Charlotte Department of Transportation

Memorandum

Date: March 26, 2008

Subject: Rezoning Petition 08-066: Located on the northwest corner of North Tryon Street and West W.T. Harris Boulevard

**SITE PLAN/
TECHNICAL
DATA SHEET**

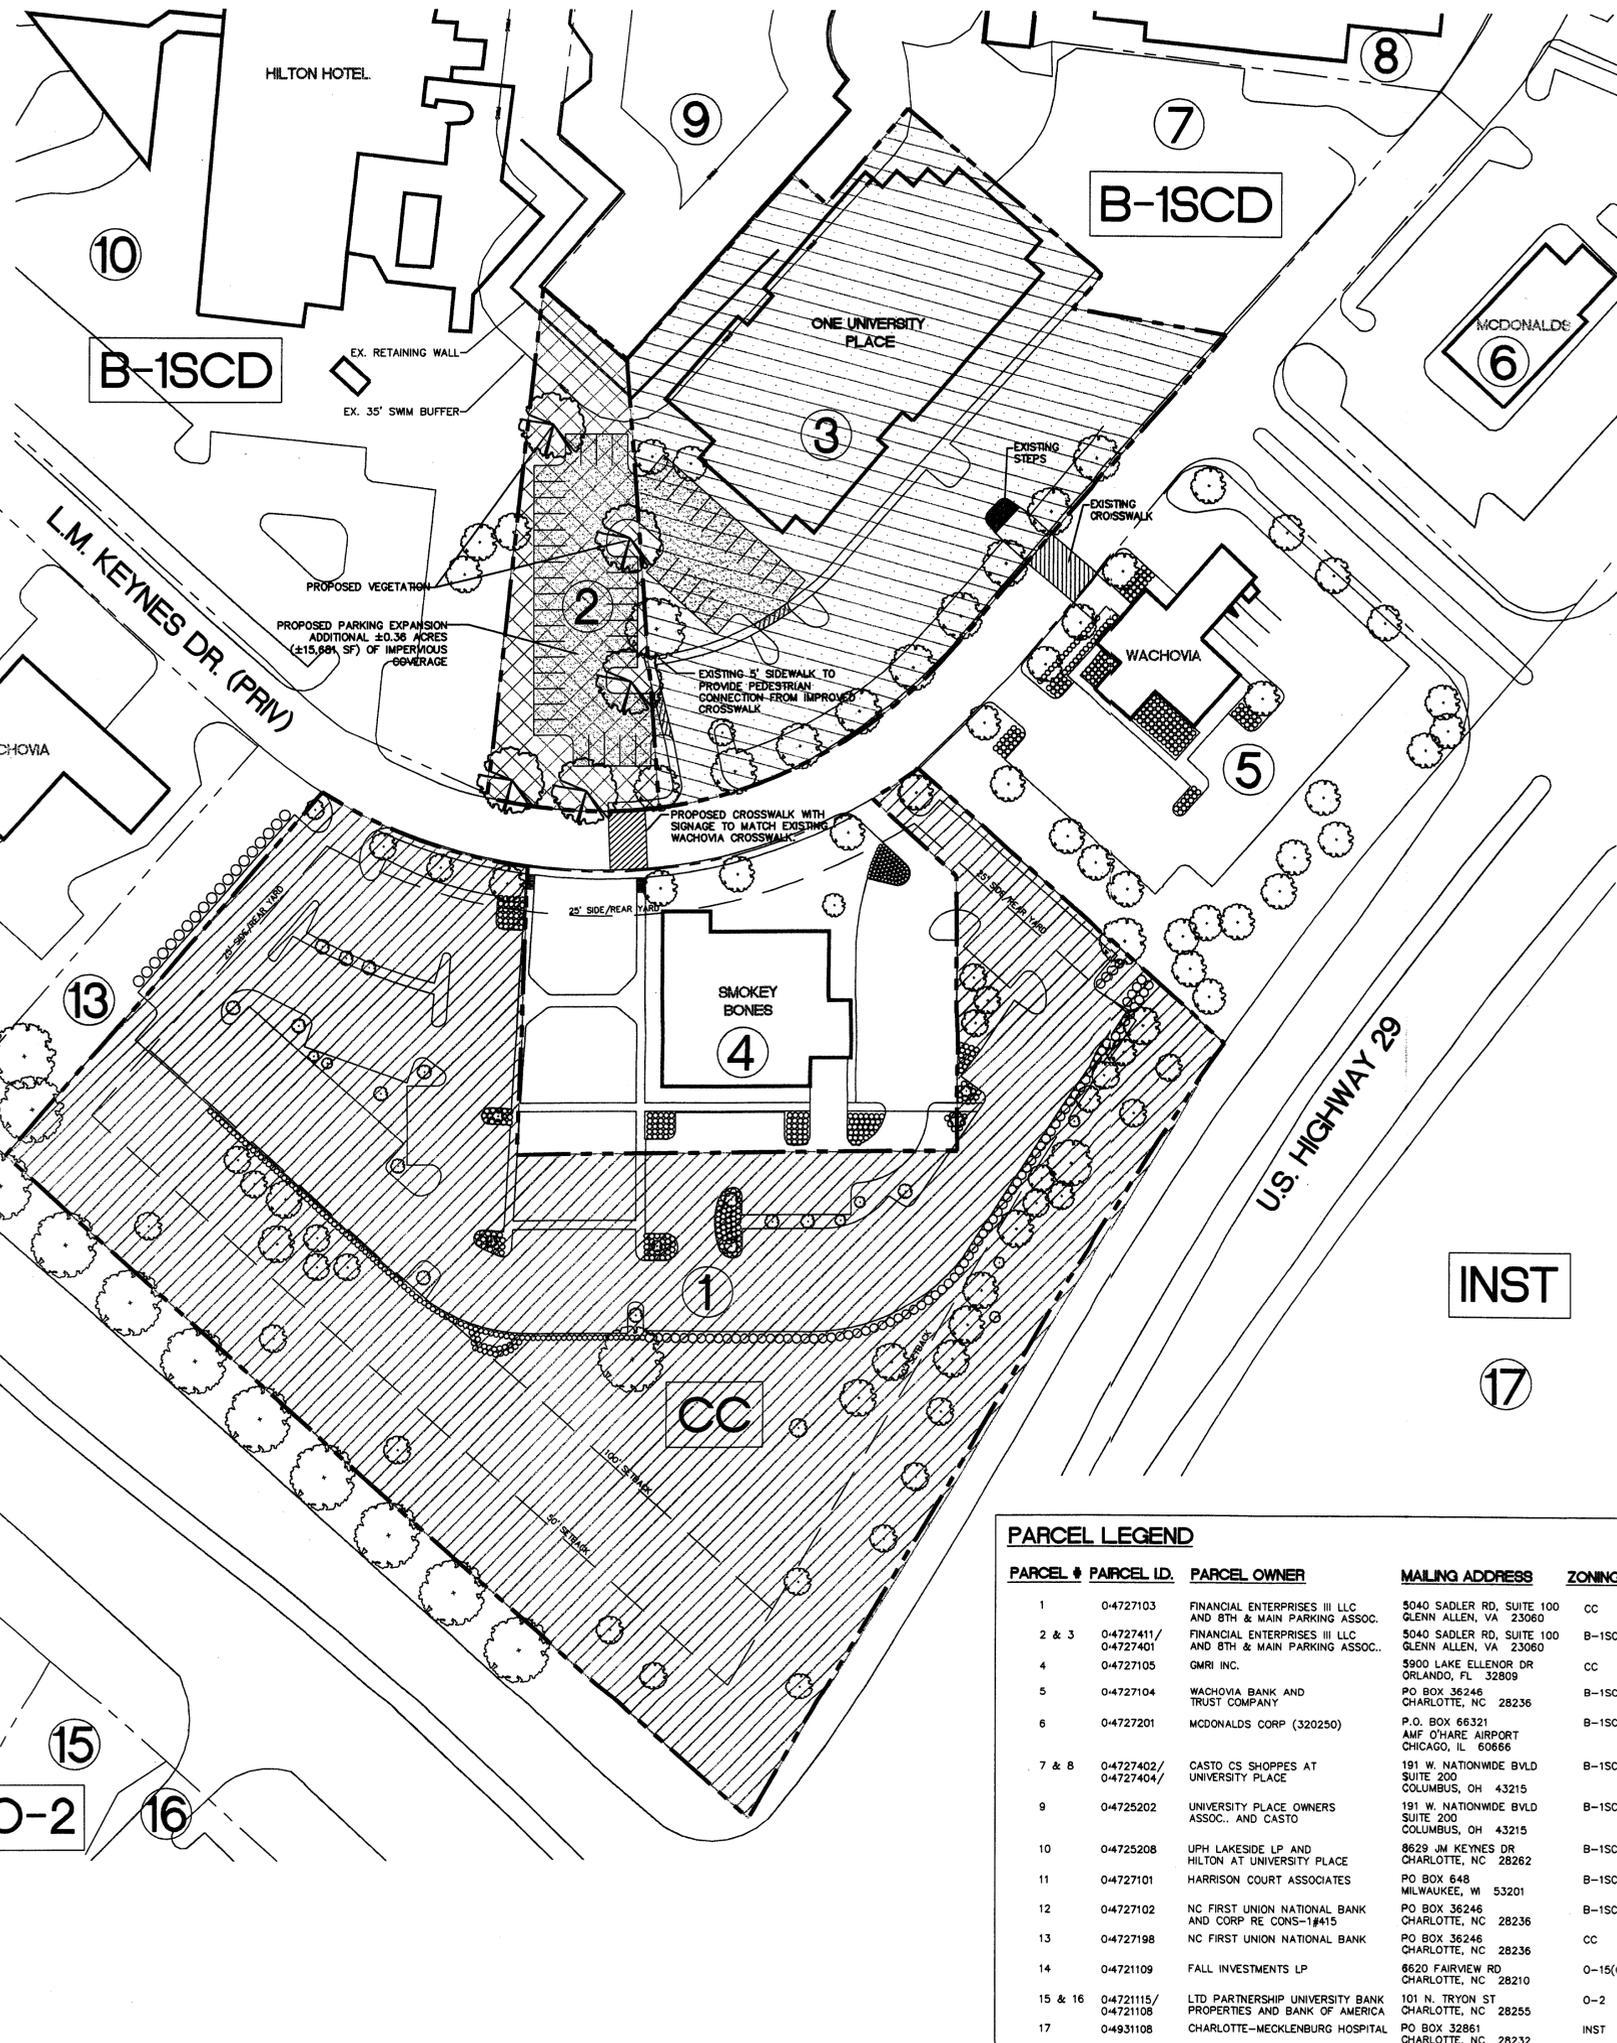
1. Curb and gutter and 6-foot sidewalk need to be constructed along the site's North Tryon Street frontage.
2. A 10-foot shared bike/pedestrian trail needs to be constructed along the site's WT Harris Boulevard frontage.
3. WT Harris Boulevard is a Parkway requiring a minimum of 200 feet of right-of-way. North Tryon Street is an Avenue requiring a minimum of approximately 165 feet of right-of-way to accommodate 6 through lanes, bike lanes, and light rail. We request that the developer/petitioner convey right-of-way in fee simple to meet these requirements, measuring 100 feet and 82.5 feet from the centerlines of these two streets, respectively.
